CITY OF ALBUQUERQUE

**RE: Event Center
1611 Airtech Ct. SE
Grading and Drainage Plans
Engineer's Stamp Date: 05/14/24
Hydrology File: N15D017**

Based upon the information provided in your submittal received 05/15/2024, the Grading & Drainage Plans **are not** approved for Building Permit and Grading Permit. The following comments need to be addressed for approval of the above referenced project:

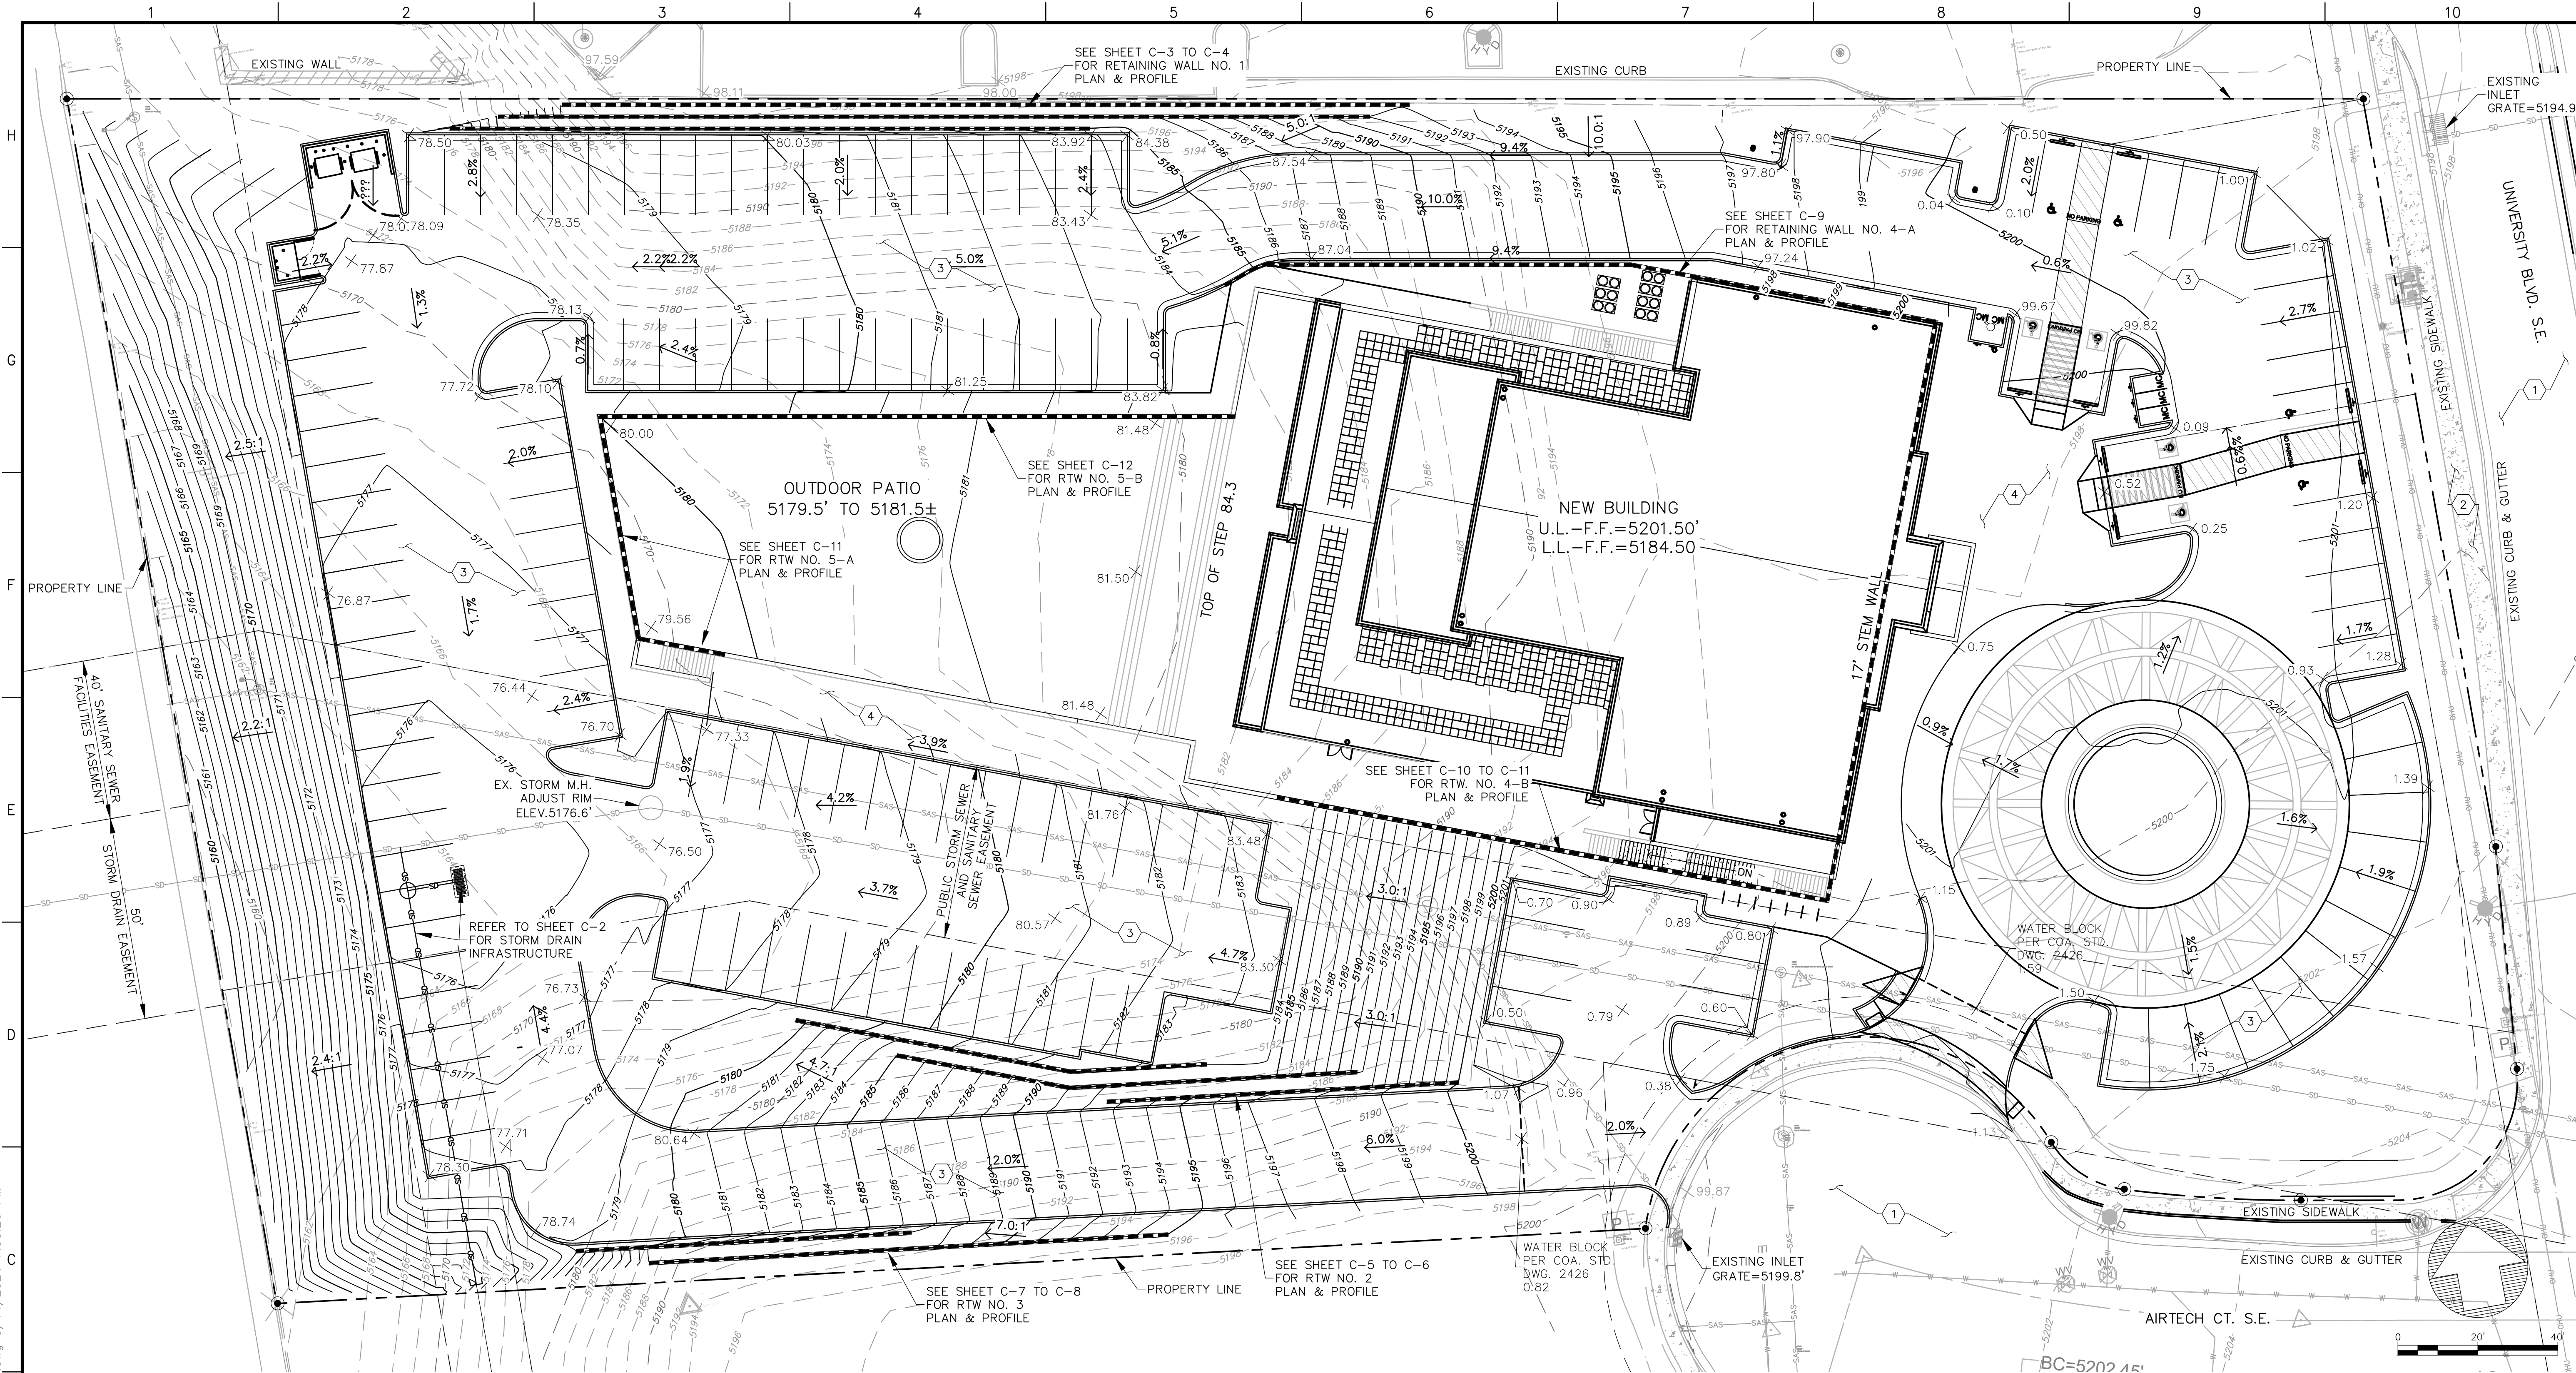
1. The entrance to off the knuckle on Airtech Court has a huge existing inlet which needs to stay in place due to the flows and grades of Airtech Court. This entrance and parking will have to be rethought in order to get built.

7. The proposed grades in the rear are not 3:1, therefore please add a note under Grading Notes. "Side slopes need to be stabilized with Native Grass Seed (per City Spec 1012) with Aggregate Mulch or equal (Must satisfy the "Final Stabilization criteria" CGP 2.2.14.b.)".

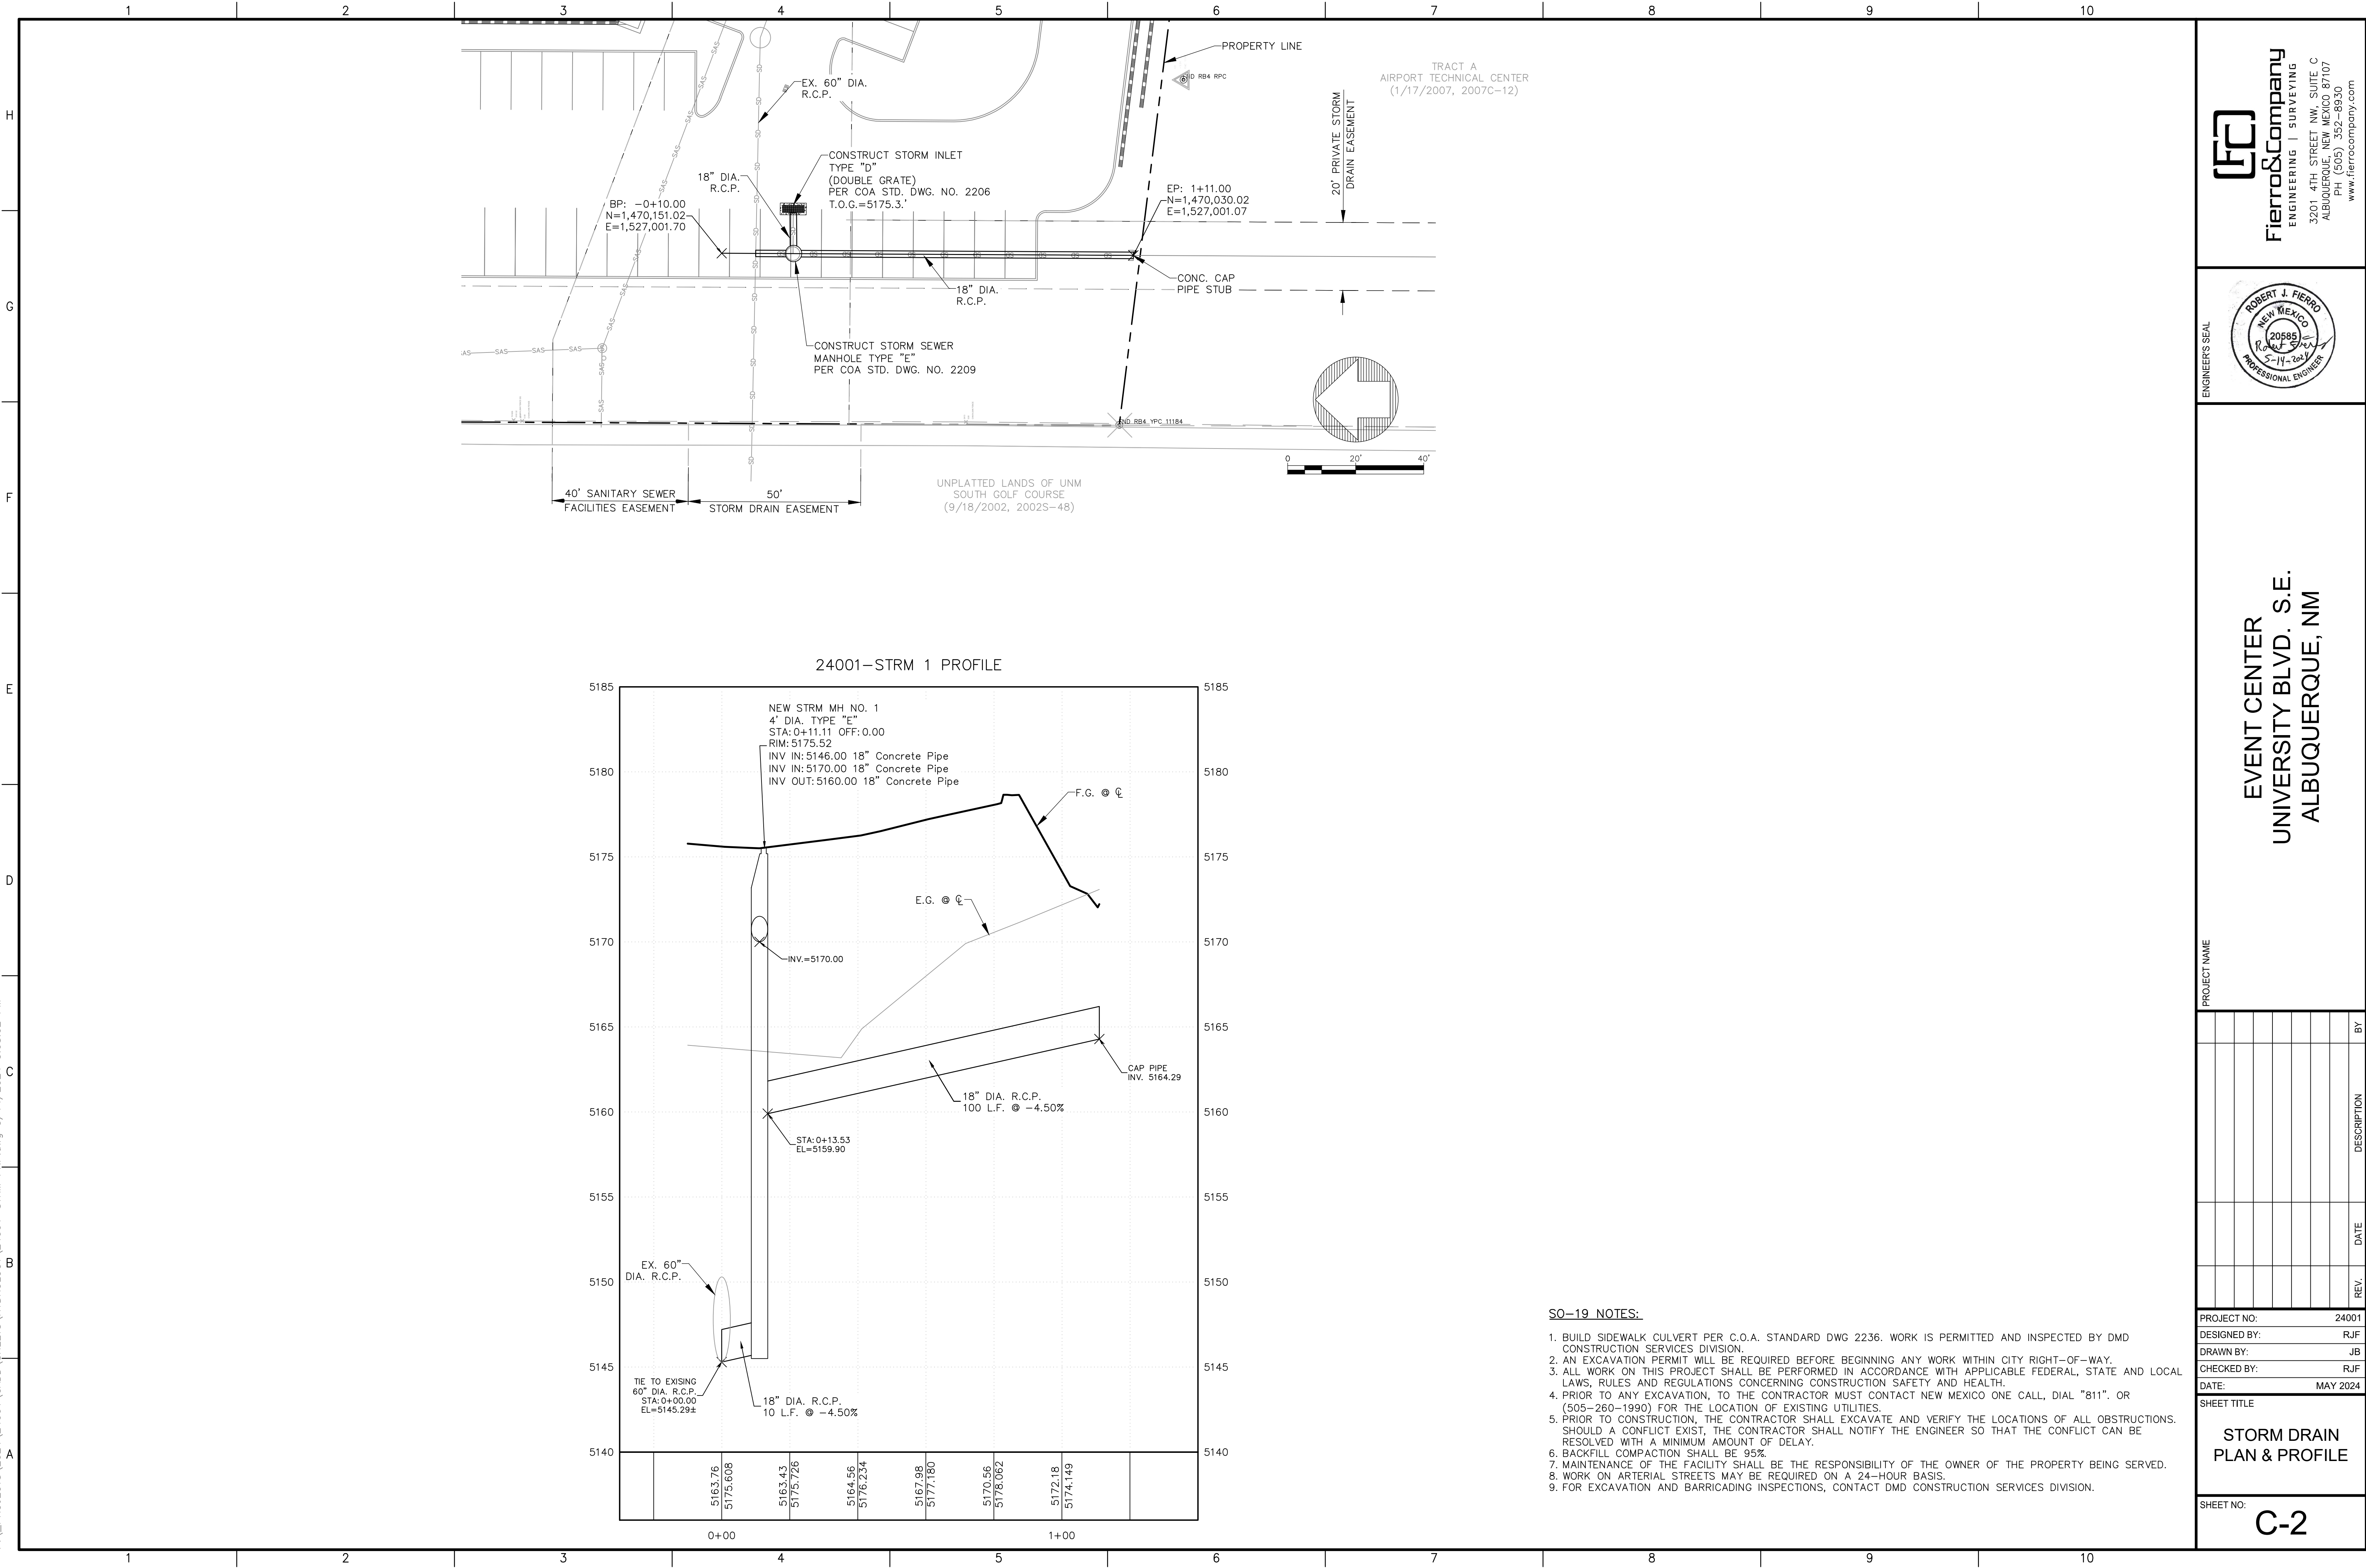
4. Please note that adjusting the elevation to the existing manhole will also be required to be included in the Work Order since this is more than a simple adjustment. It appears that it will have to be moved up about 10 feet.

5. I would highly recommend that the existing manhole rim elevation be topo'd along with the inverts of the 60-in storm sewer.
6. Also looking at the as-builts and the amount of fill that is being brought in on top of the existing 60-inch RCP Class III. This will have to be replaced with a 60-inch RCP Class IV due the cover and original installation.
